Application by Chrysaor Production (UK) Limited for an Order Granting Development Consent for the Viking response CCS

Comments on submissions received at Deadline 2 from Lincolnshire County Council

Drawing title
LAYDOWN, WELFARE AND PARKING AREA
Regulation 5.2 (o)
Application Document Reference 4.13
(Sheet 1 of 1)

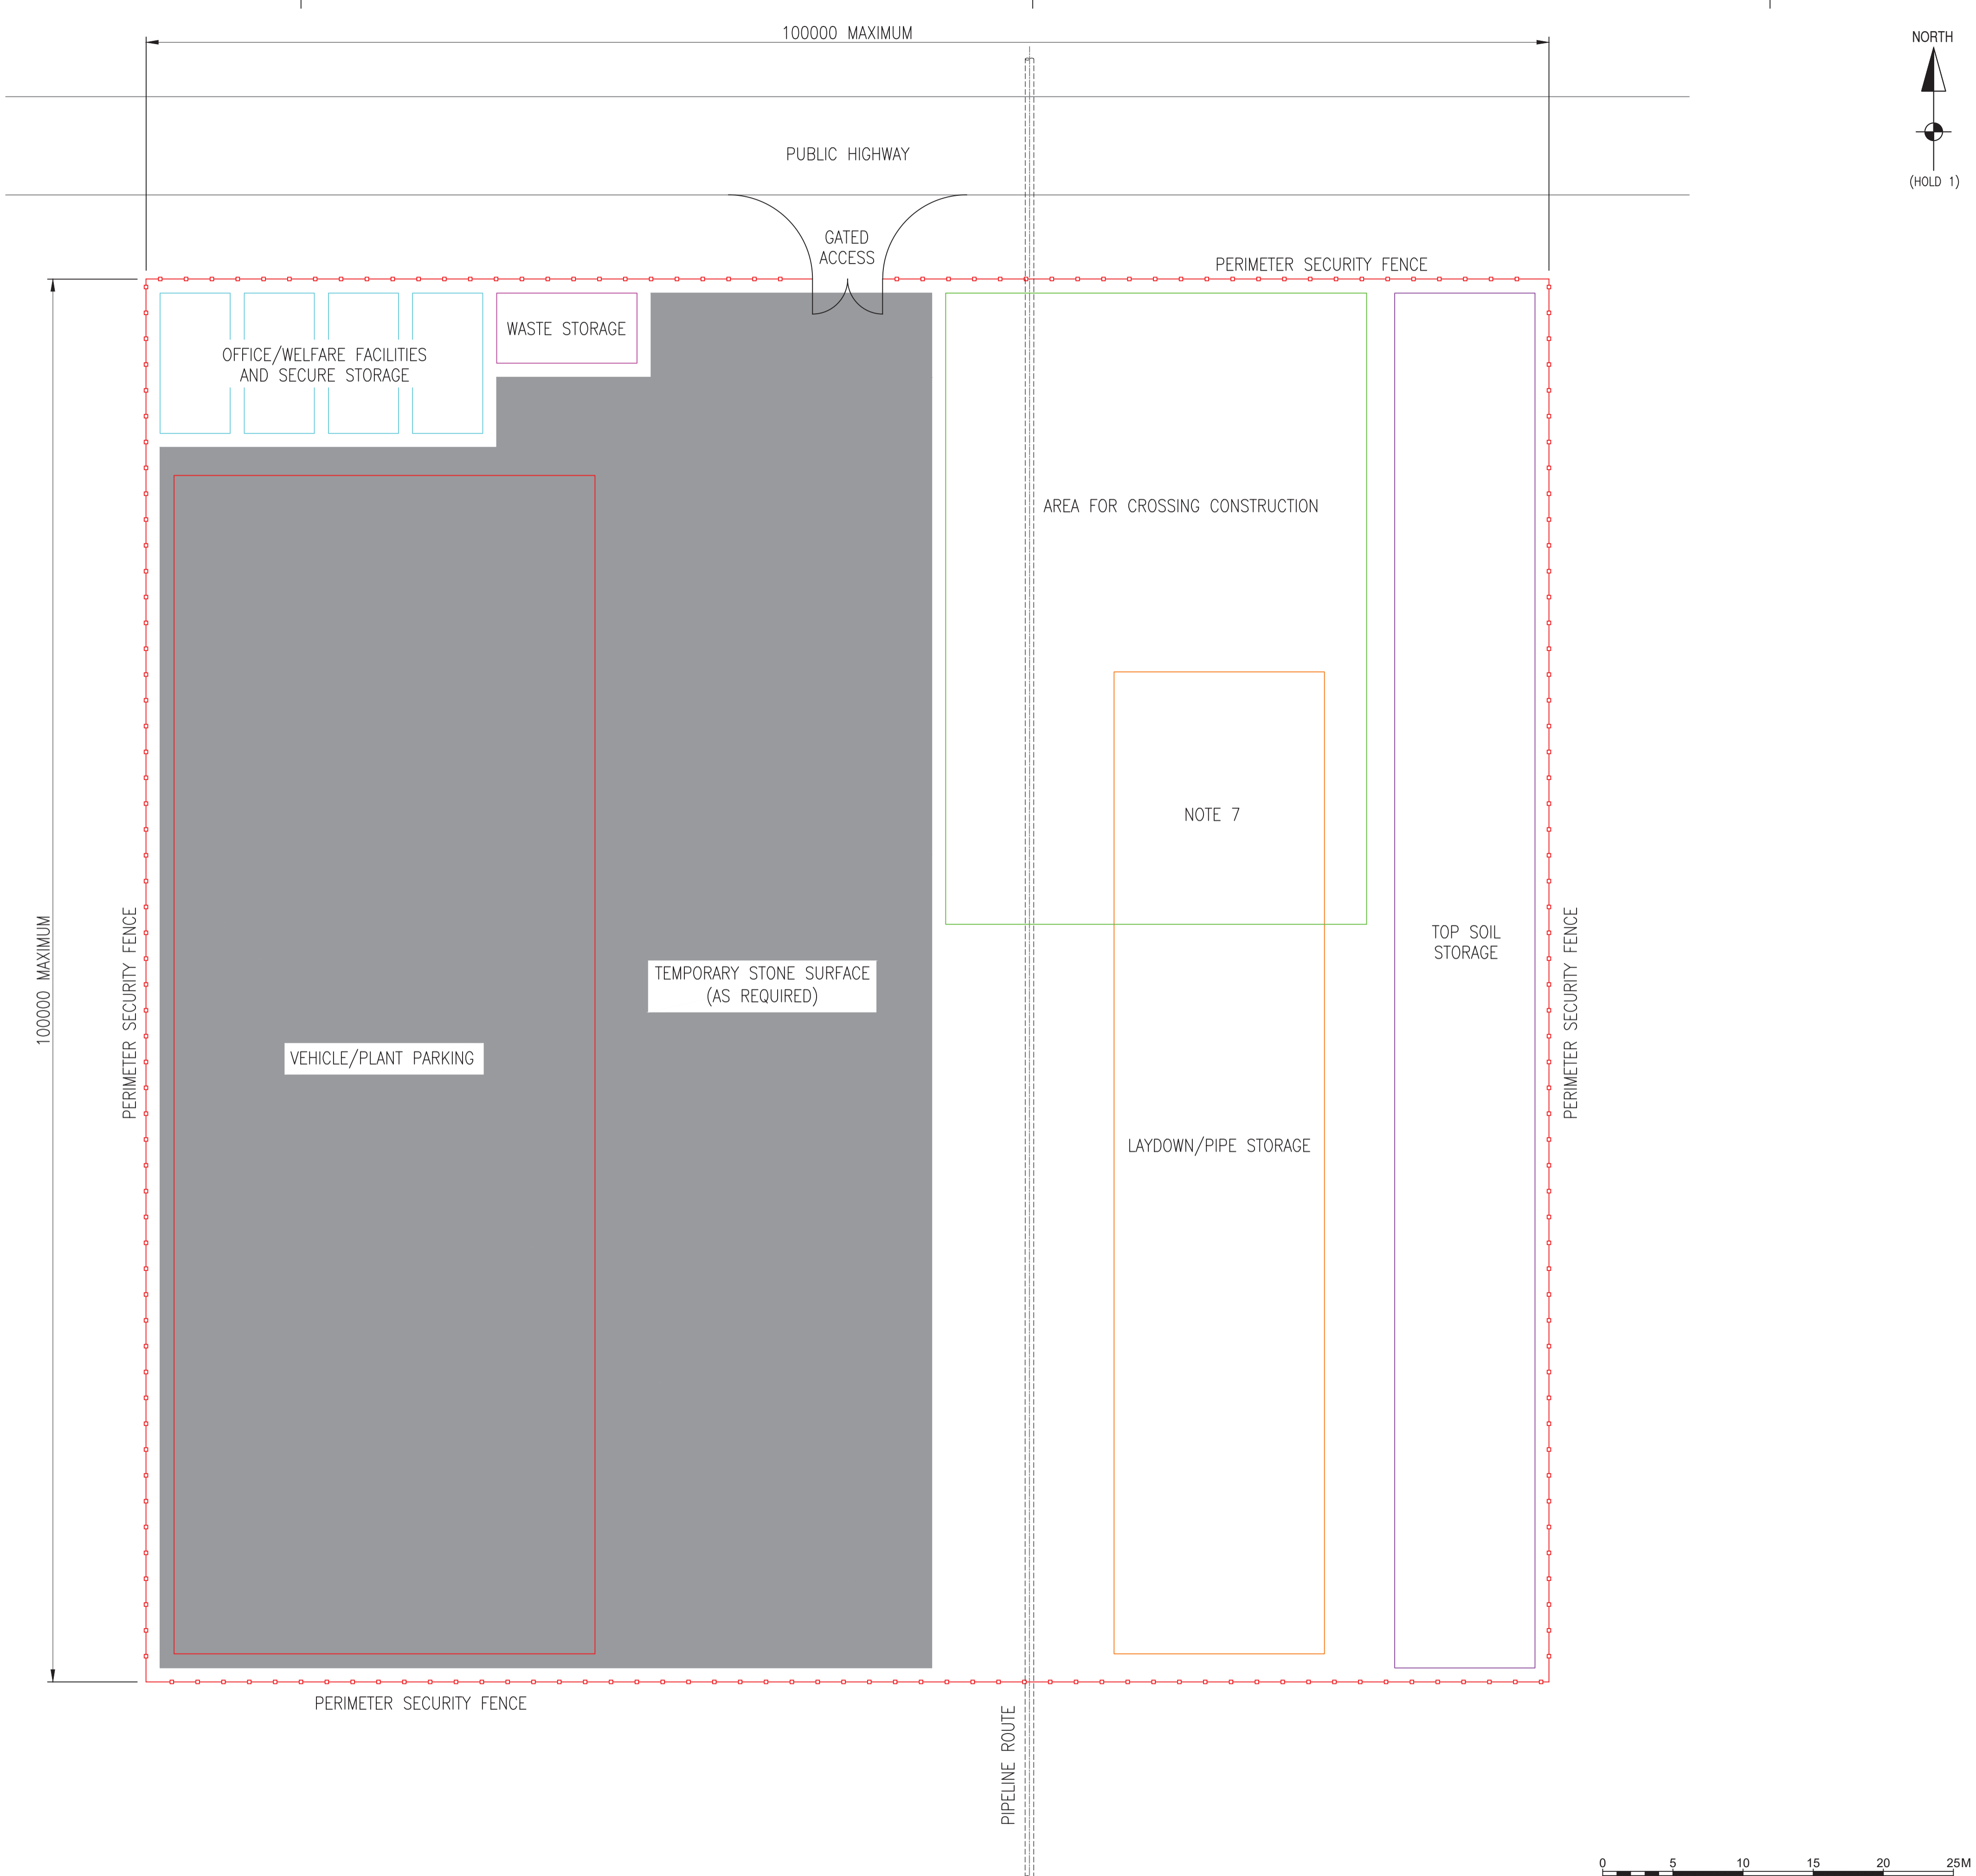
D12 is *'Limiting stripping for construction compounds, laydown, welfare and parking areas, haul roads and other associated works in areas where archaeology is recorded to avoid disturbance, and instead using geotextile and stone over topsoil.'*

Again while this is very positive as a commitment it would depend on the nature, significance and depth of archaeology whether this would be an appropriate mitigation measure, for example human skeletal remains may be found at no great depth in agricultural landscapes and they would be damaged and destroyed by this mitigation response. Again

the appropriate level and type of mitigation will need to be informed by the trenching results.
